**Consultation Response from KC, Conservation & Design****2024/92145 Railway Viaduct MDL1/27, Union Mill, Mill Lane/Grange Road, Batley****Discharge conditions 3 (OLE brackets), 4 (mortar specification), 5 (masonry repairs) on previous permission 2022/90276 for Listed Building Consent for installation of four overhead electric line equipment portals on piers 3, 7, 11 & 15 with supporting wall brackets****Date Responded: 08.08.2024****Responding Officer: S Pickles****Responding Ref:****Condition 3 – OLE Brackets**

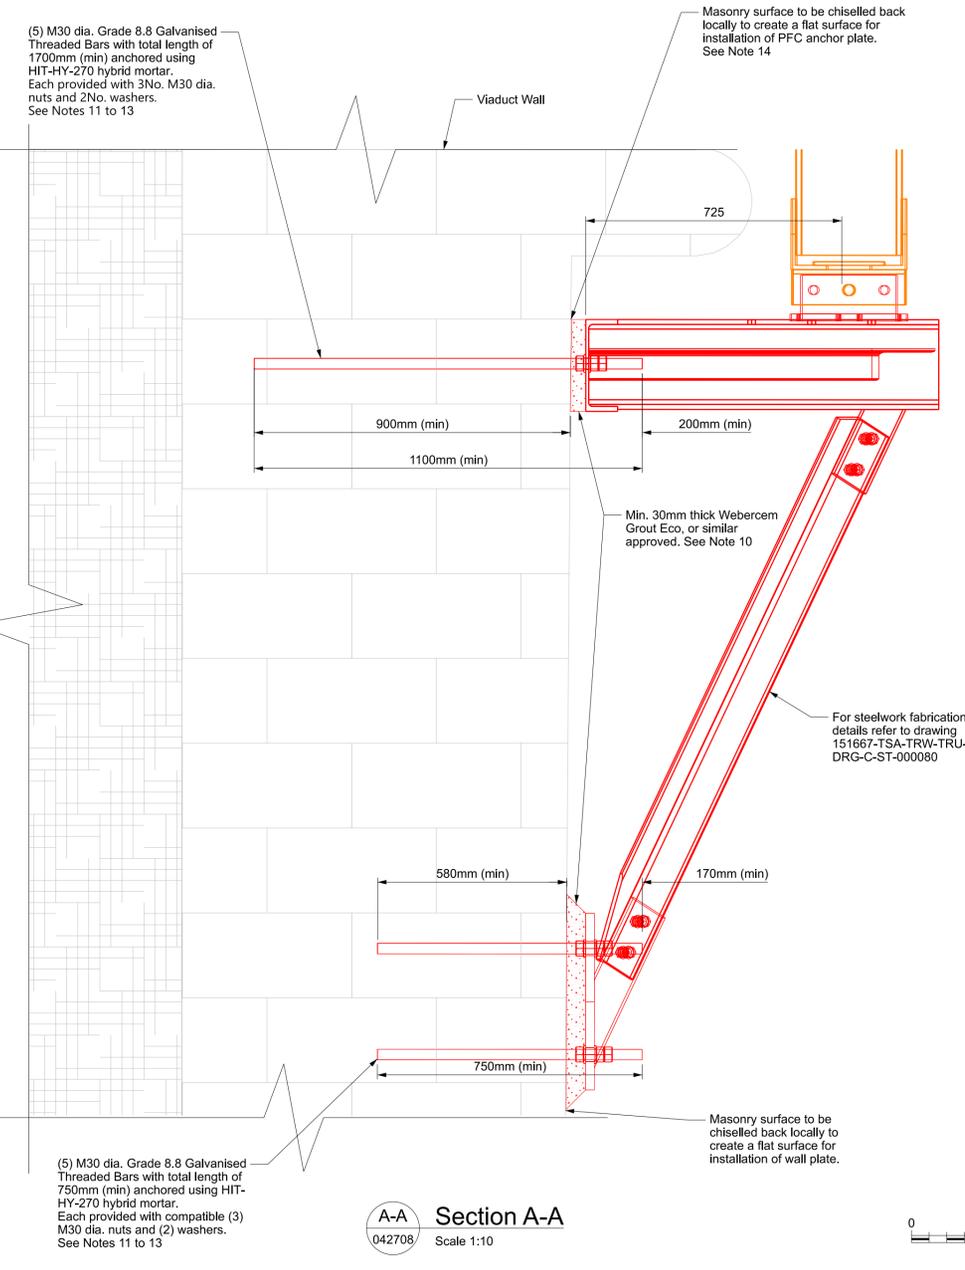
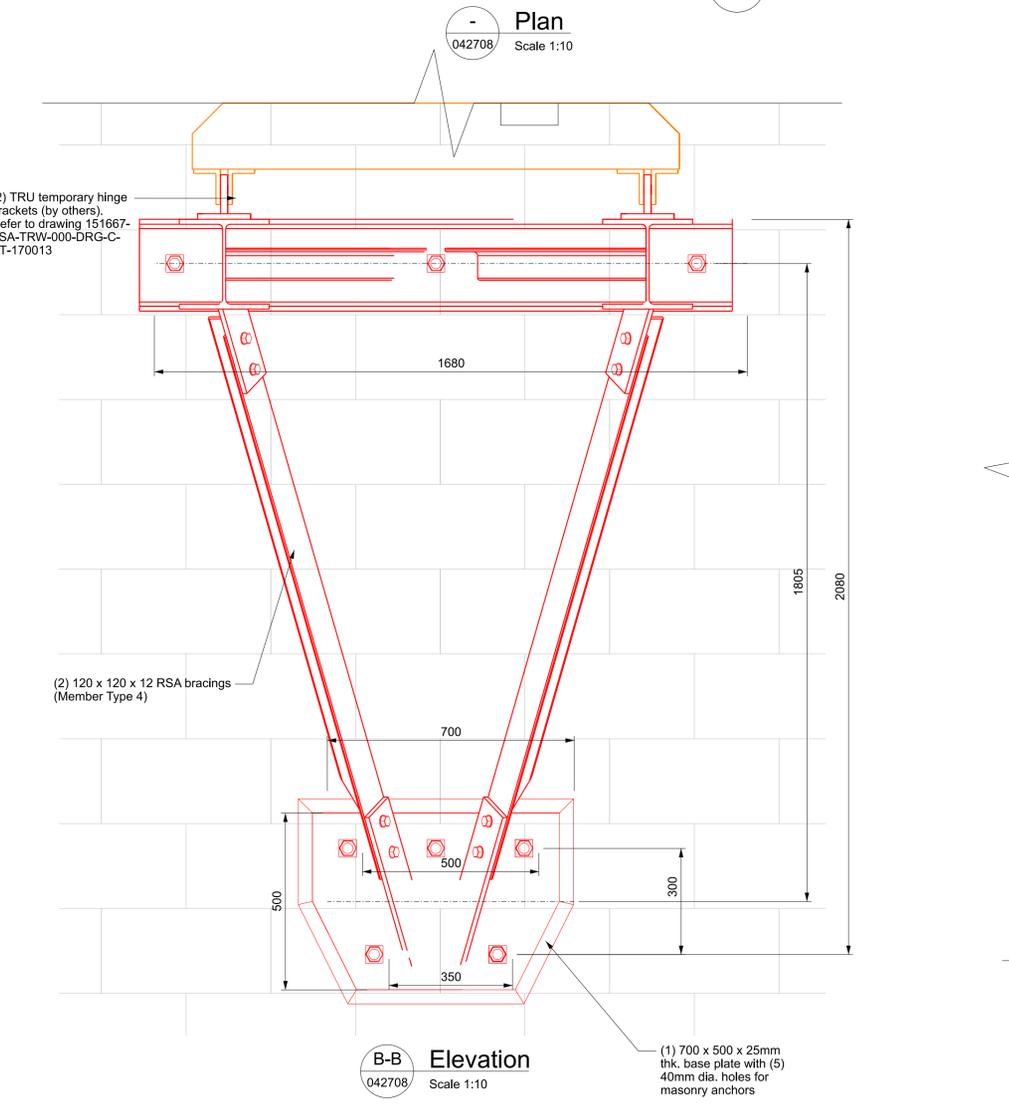
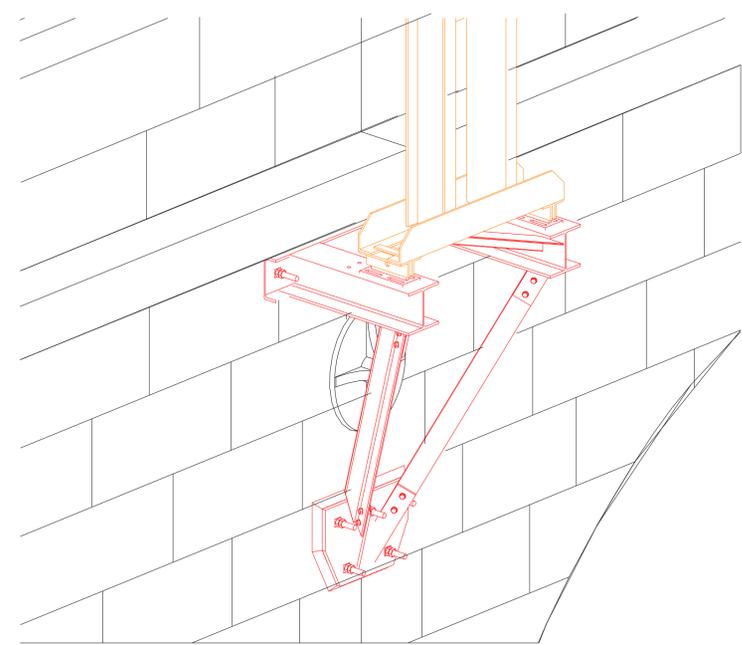
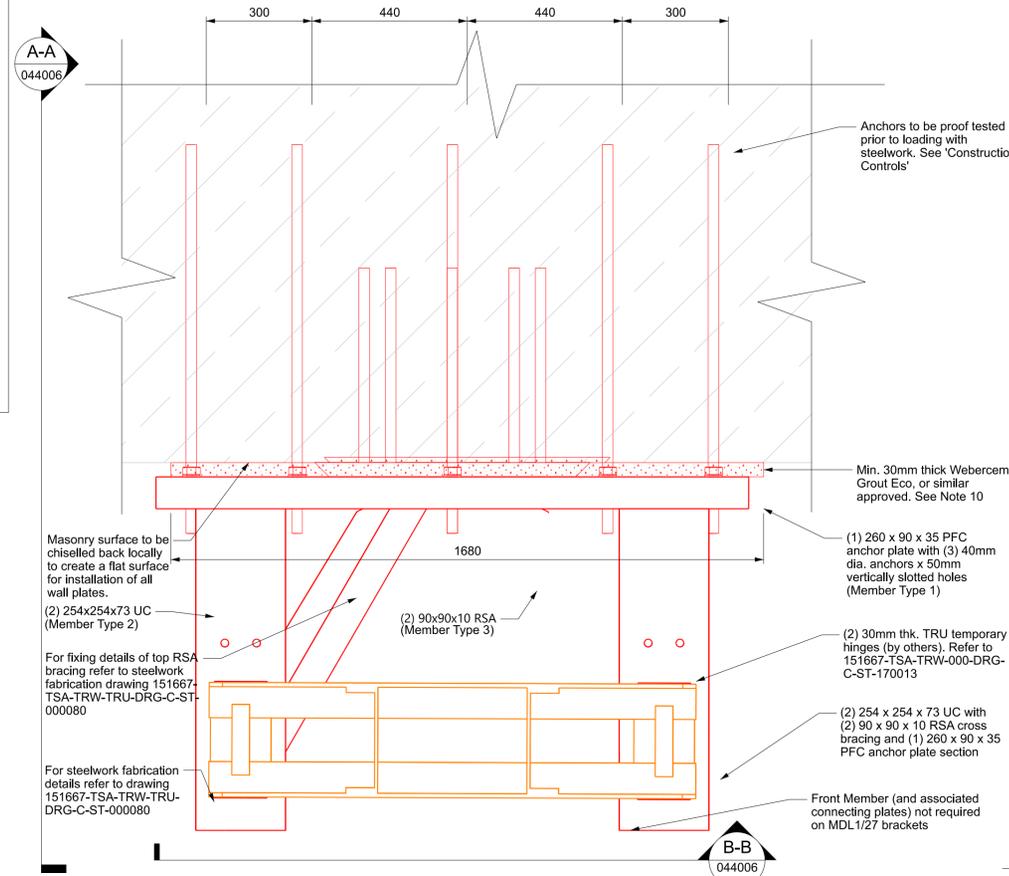
We note that with the brackets there will be a need for areas of the stonework to be flattened off to create the required surface for the bracket plate. We note that this is either to be done using hand tools or if considered necessary to be undertaken using rotary tools. This is accepted as necessary however, care should be taken to ensure that the area affected is kept to the absolute minimum and that no additional harm is incurred to the surrounding stonework. The use of cold chisels may incur greater damage to the stonework and surrounding stonework, and we would advise that their use is entirely avoided. Precision chisels should be used if undertaken by hand.

We also acknowledge that Webercem Grout Eco is to be used. We understand why this is specified for use as opposed to lime, however, we have some concerns about the long-term impacts in terms of whether the grout given it is cementitious will de-bond itself from the stonework, however, we appreciate this is in addition to the bolts/ anchors.
